**From:** Sam Stonehouse  
**Sent:** Tue, 7 Dec 2021 15:16:03 +0000  
**To:** Burlow, Alexa  
**Subject:** RE: DC/21/2245/FUL - Rathkeltair Lodge, Barton Hill, Fornhan St Martin

**From:** Burlow, Alexa <[alexa.burlow@westsuffolk.gov.uk](mailto:alexa.burlow@westsuffolk.gov.uk)>  
**Sent:** 26 November 2021 10:46  
**To:** Sam Stonehouse <[sam@evolution-planning.co.uk](mailto:sam@evolution-planning.co.uk)>  
**Subject:** DC/21/2245/FUL - Rathkeltair Lodge, Barton Hill, Fornhan St Martin

**GARAGING FIRST FLOOR plan**  
1:100

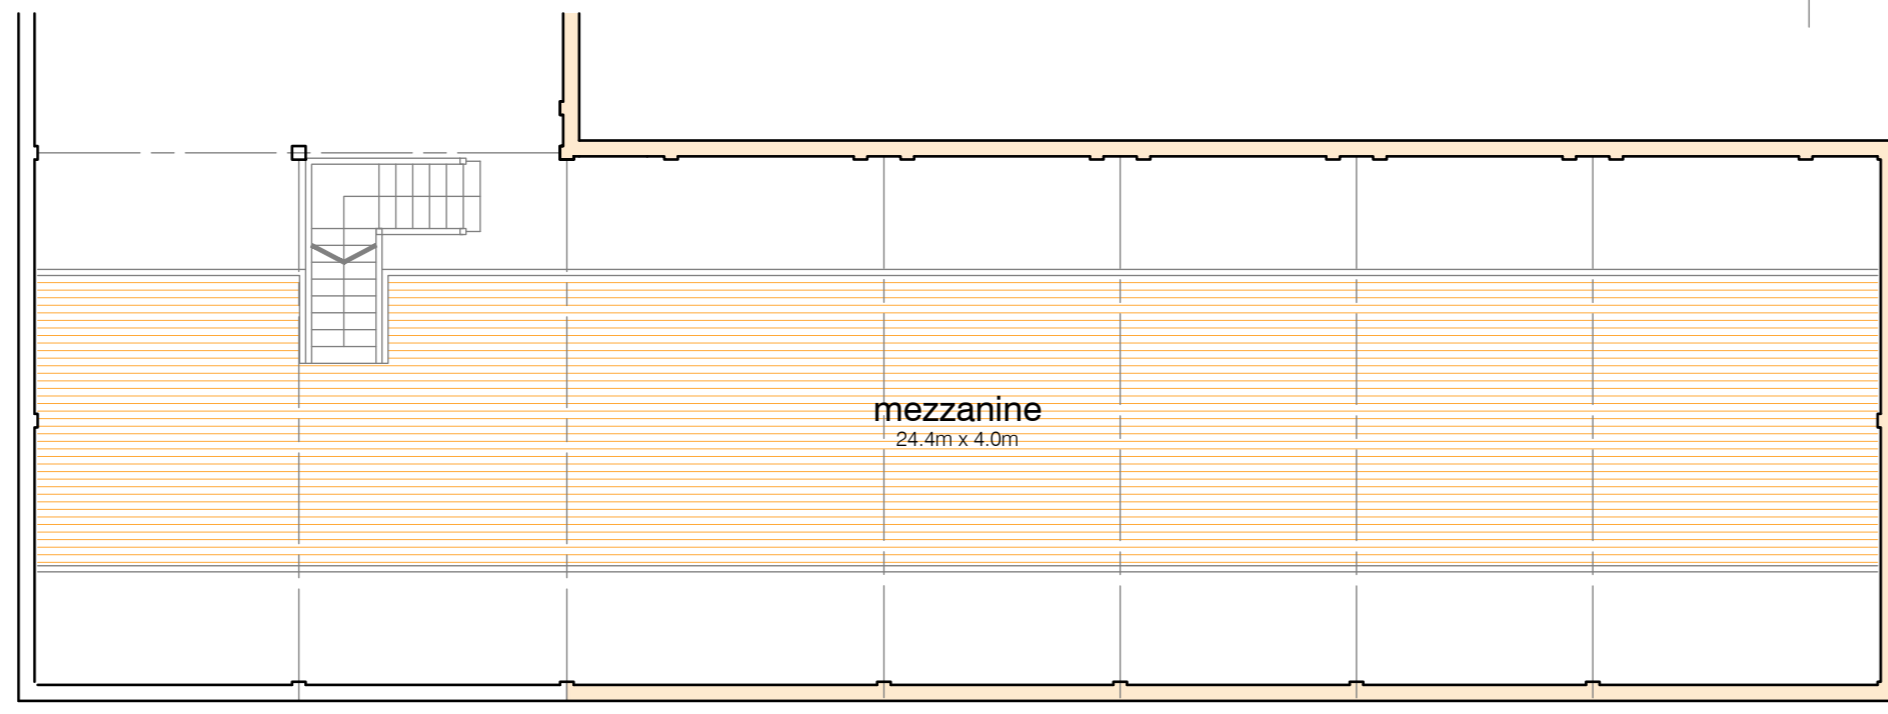
- Please provide a proposed floor plan of the mezzanine floor to the proposed garage block. *Please see updated plan 781-1b-003B.*
- The window to the boot room on the ground floor is missing off the East elevation. The east elevation shows roof lights in the first floor above the garage/workshop/store but not on the floor plans. Please amend accordingly. *Please see updated plan 781-1b-005A*

Revision A - 29 November 2021
Site red line amended to include accesses.
**781-1 001
A**
29.11.21
1:200
August 2021

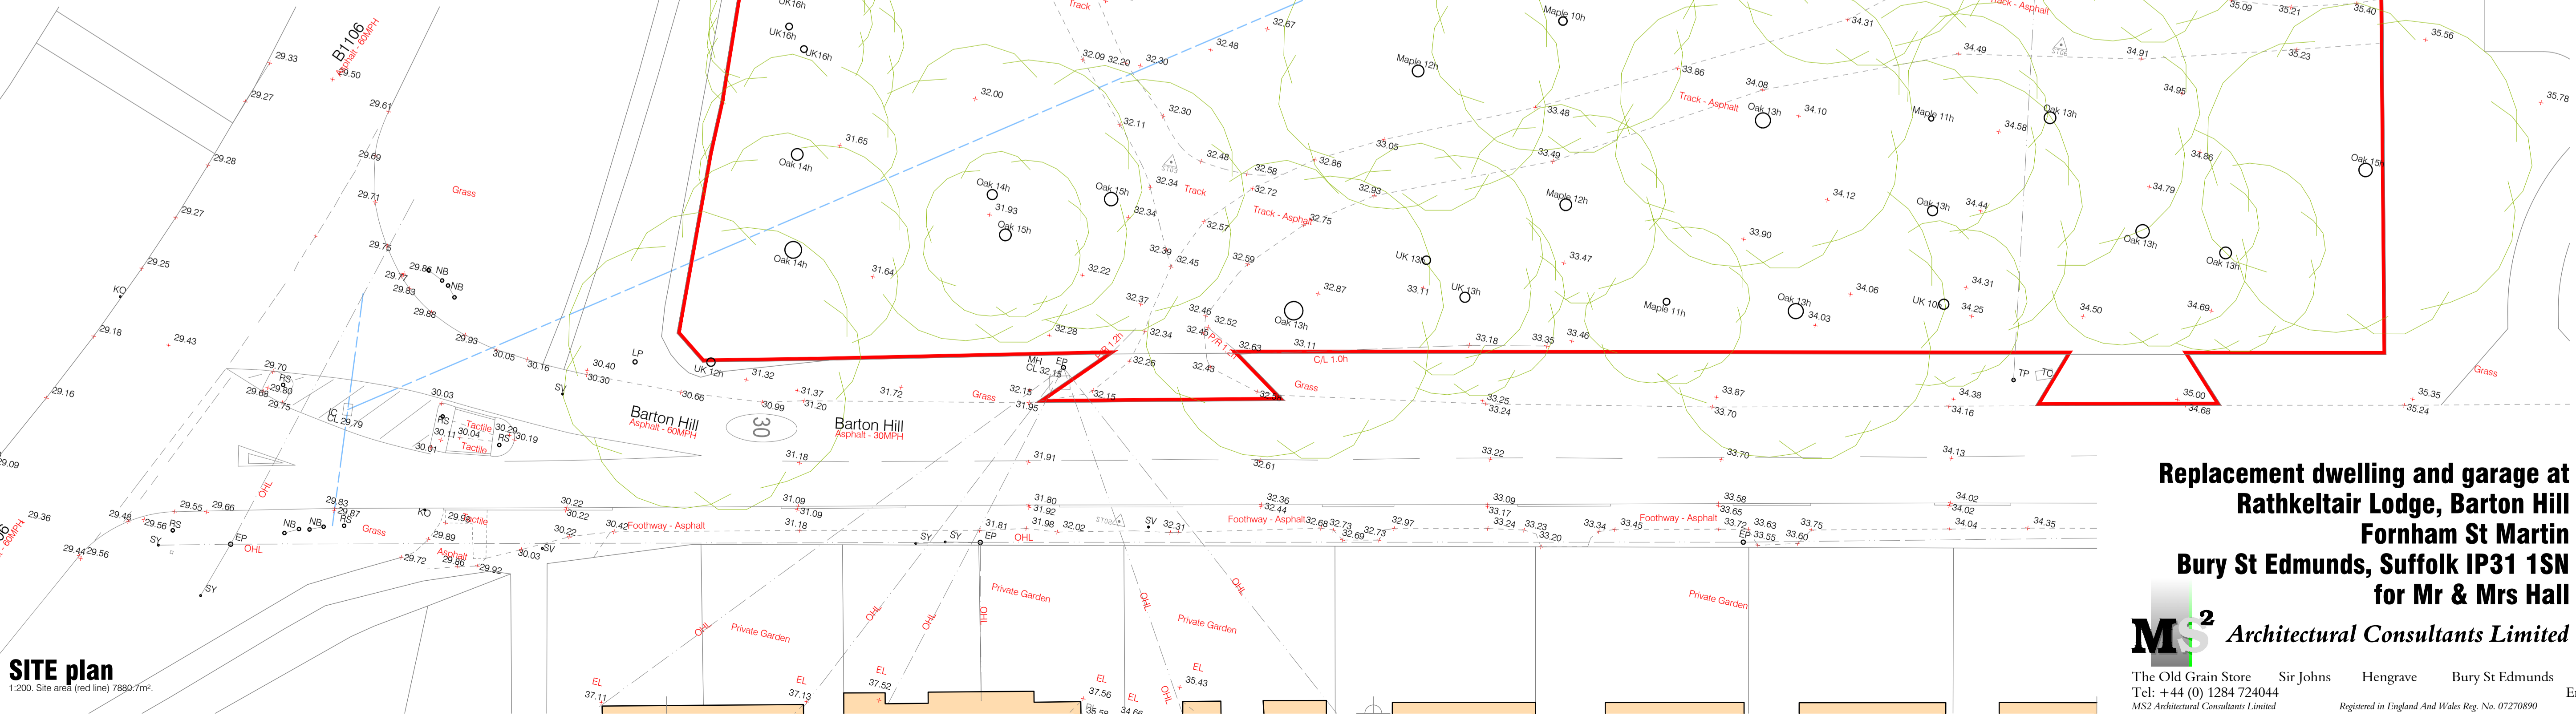
- The red outline must include the access to the public highway, on both the block plan and site location plan. If the applicant does not own the land between the site and the highway you will

need to serve notice on the owners and change the application form to a certificate B. Please amend accordingly. *This has been updated on plan 781-1b-001A*

Revision B - 29 November 2021  
Site red line amended to include accesses.  
REV A 7 - 10 2021  
Garage repositioned patio reduced  
**781-1 002 B**  
29.11.21  
1:200 1:1250 1:5,000 August 2021  
Suffolk IP28 6NB  
Email: projects@ms2.co.uk  
VAT Reg. Number 571 3766 26

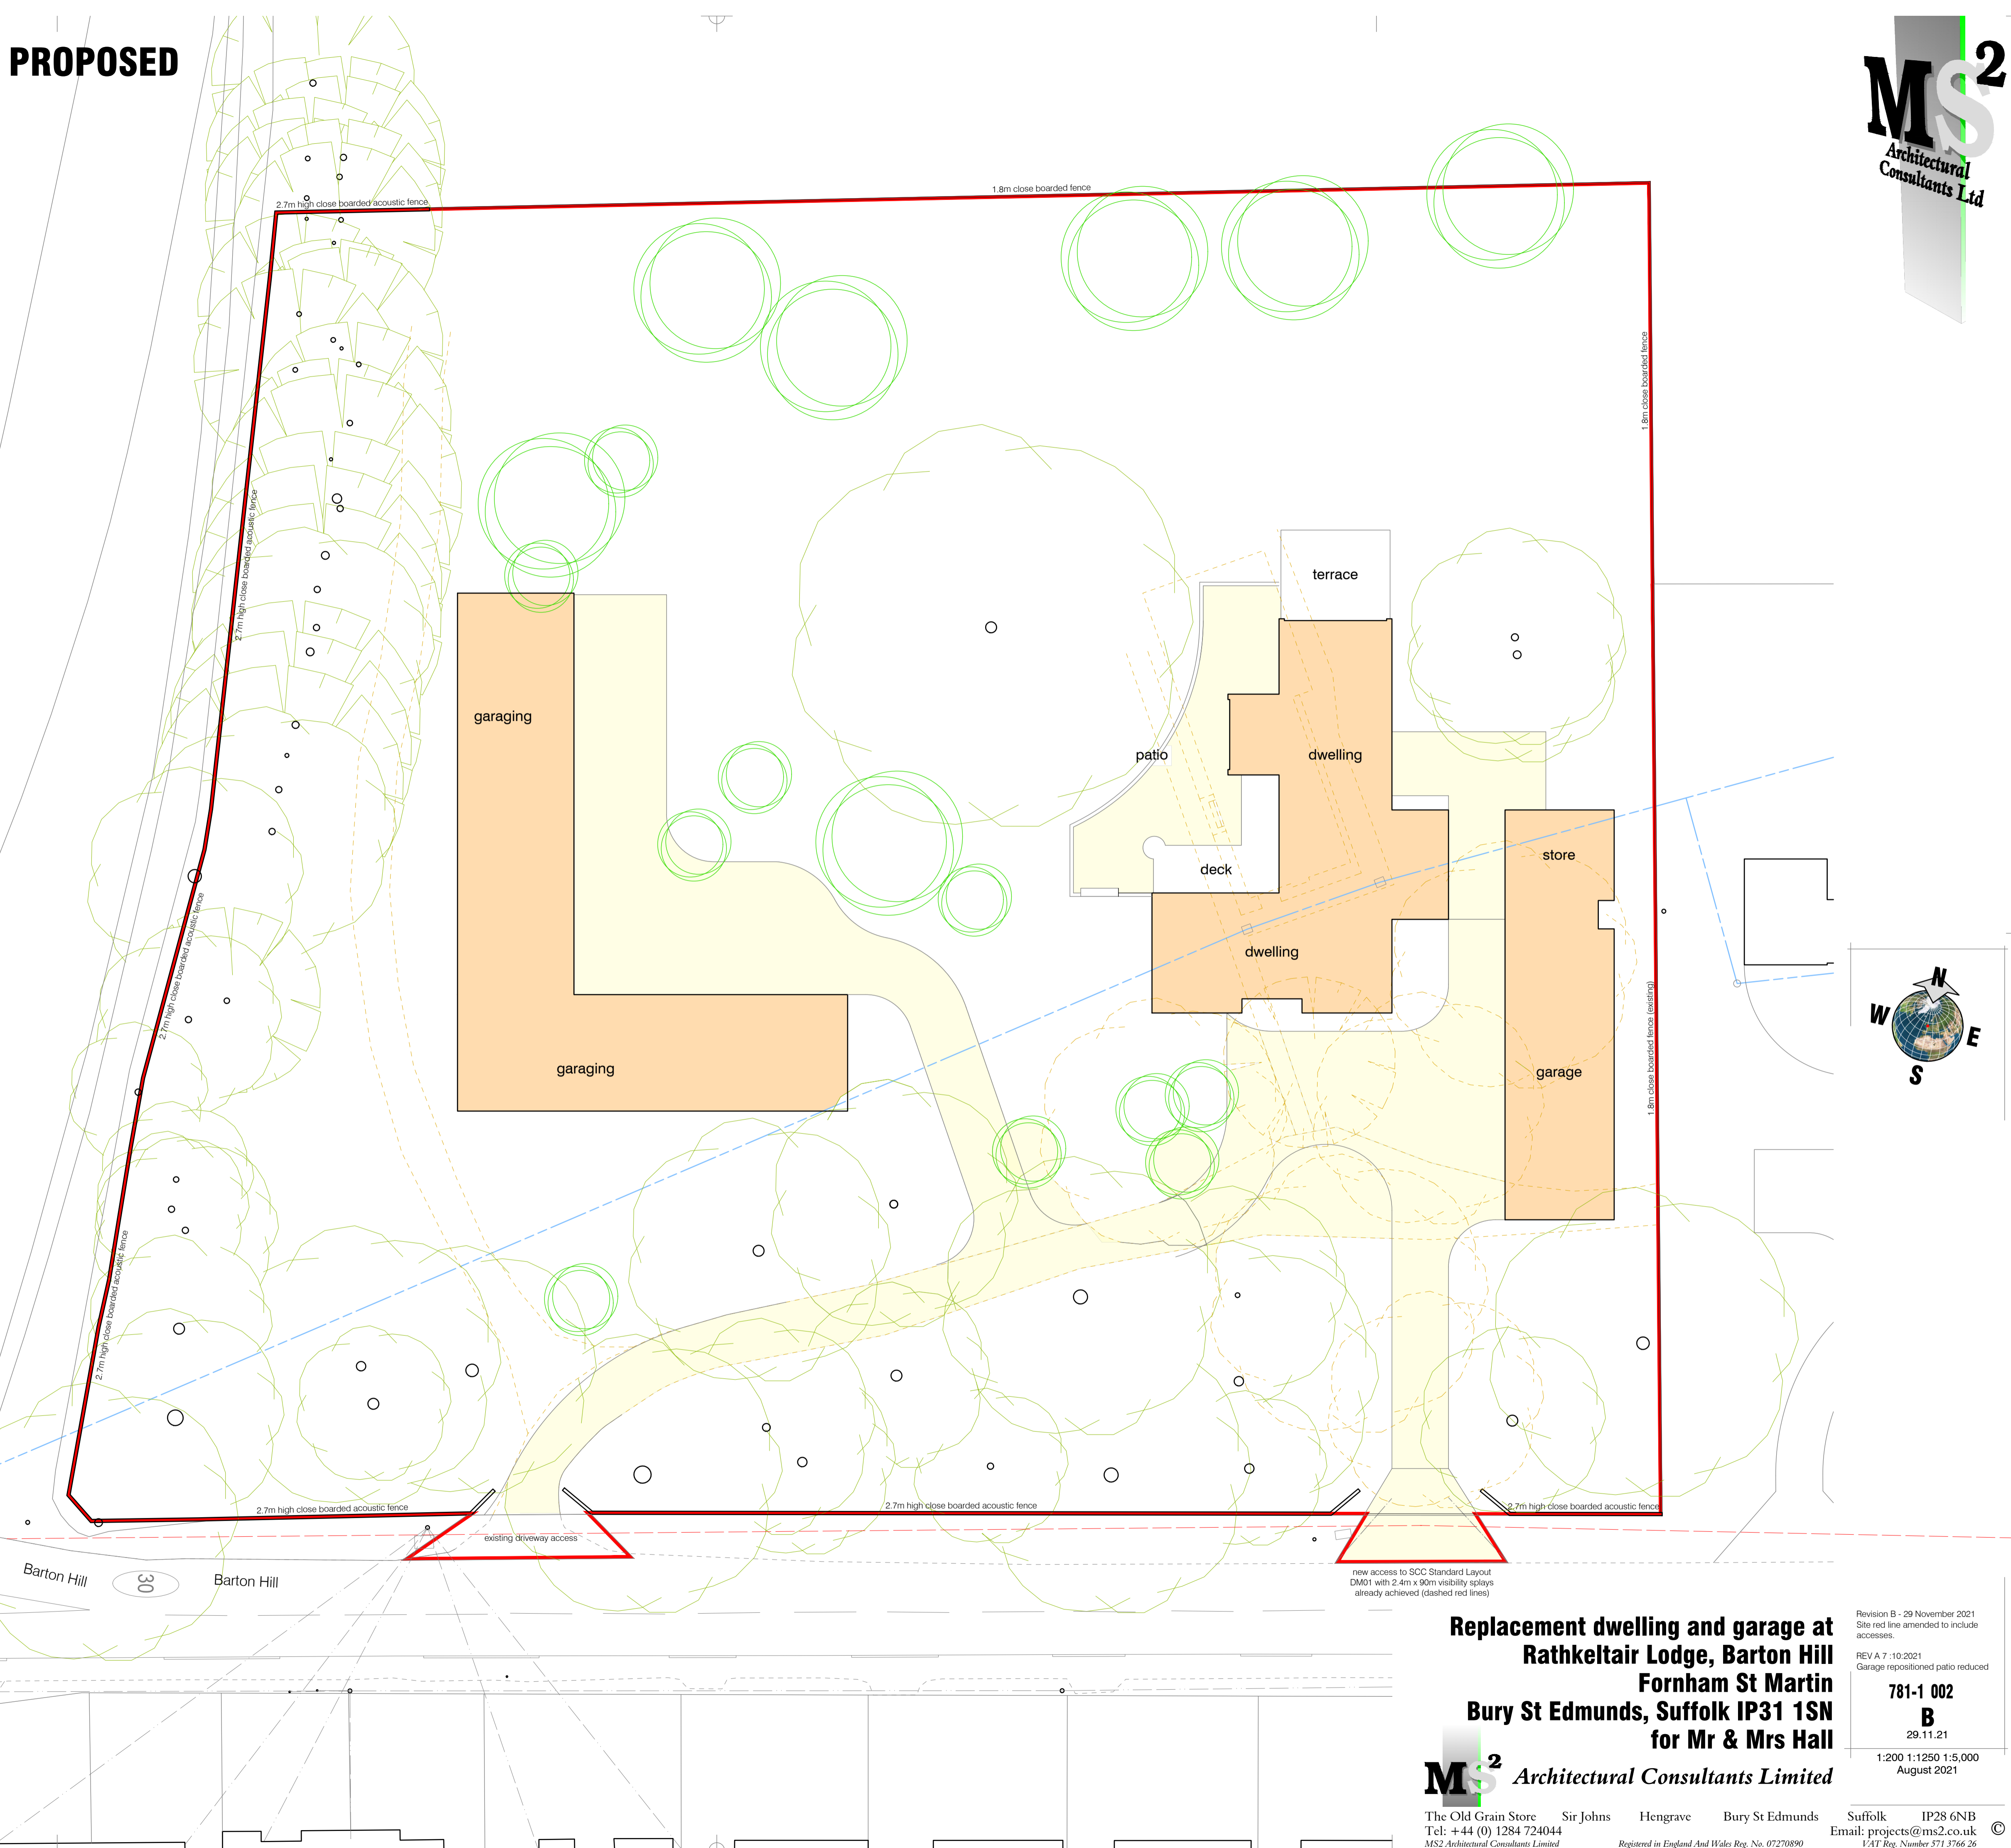
The proposed block plan it looks as you are proposing a 2.7m close boarded acoustic fence to the south, west and north boundaries, as well as gates at both the accesses – if they are not already in place that will require planning permission.

We will need proposed elevations of this and it should be included in any of your supporting documents i.e. Design and Access Statement or Planning Statement. If it is all in place at the moment, please amend the block plan to label it as existing.
